Appeal Decision

Appeal Ref: APP/C3810/A/10/2122908

Land at Northfields Lane, Aldingbourne, West Sussex PO20 3UH

- The appeal is made under section 78 of the Town and Country Planning Act 1990 against a refusal to grant planning permission.
- The appeal is made by Mr David Deadman against the decision of Arun District Council.
- The application Ref AL/62/09, dated 26 June 2009, was refused by notice dated 18 August 2009.
- The development proposed is described as "sand school, storage building and driveway (sand school for private use only)".

DRW NO 5 SCALE 1/100
PROPOSED ELEVATIONS

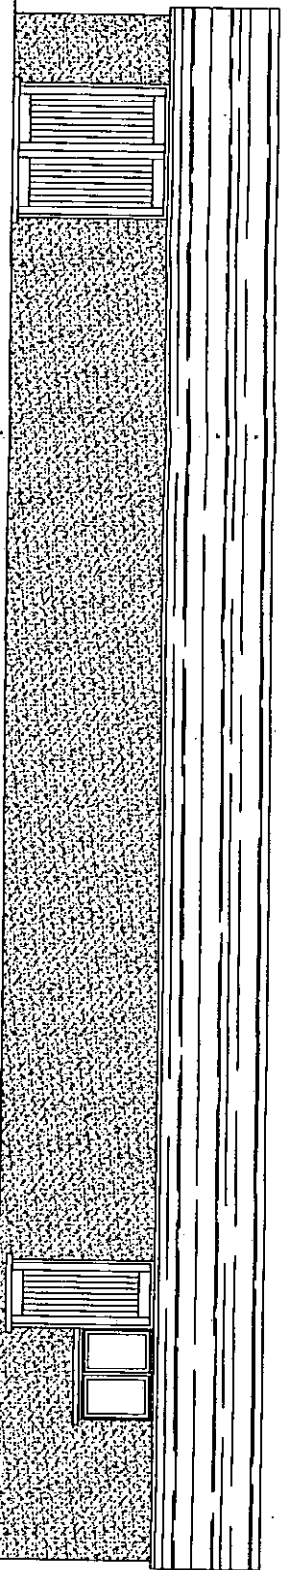
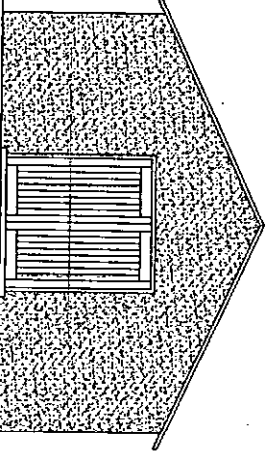
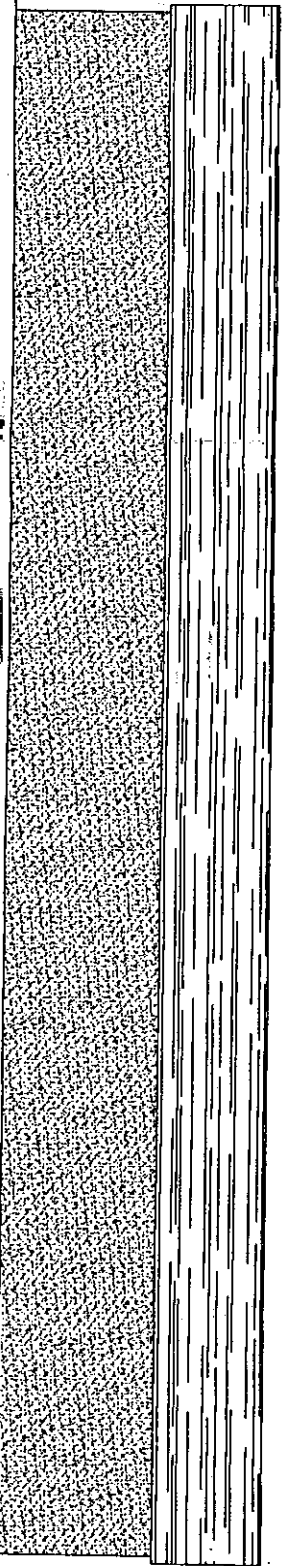
4. It was clarified at the site visit that the building would have doors in its western end elevation, although these do not appear on the floor plan. The building would be constructed of concrete panels for the walls and a fibre cement roof, but the appellant has offered to clad the walls with timber weatherboarding or barn cladding to improve the appearance. Subject to that improvement and to the provision of additional landscaping, including trees and hedging around the access to the site, I do not consider that the proposed storage building would adversely affect the character and appearance of the area.

1. The development hereby permitted shall be begun before the expiration of three years from the date of this permission.
 2. No development shall take place until full details of the materials to be used to clad the exterior of the walls of the proposed storage building have been submitted to and approved in writing by the local planning authority. The development shall be carried out in accordance with the approved details.
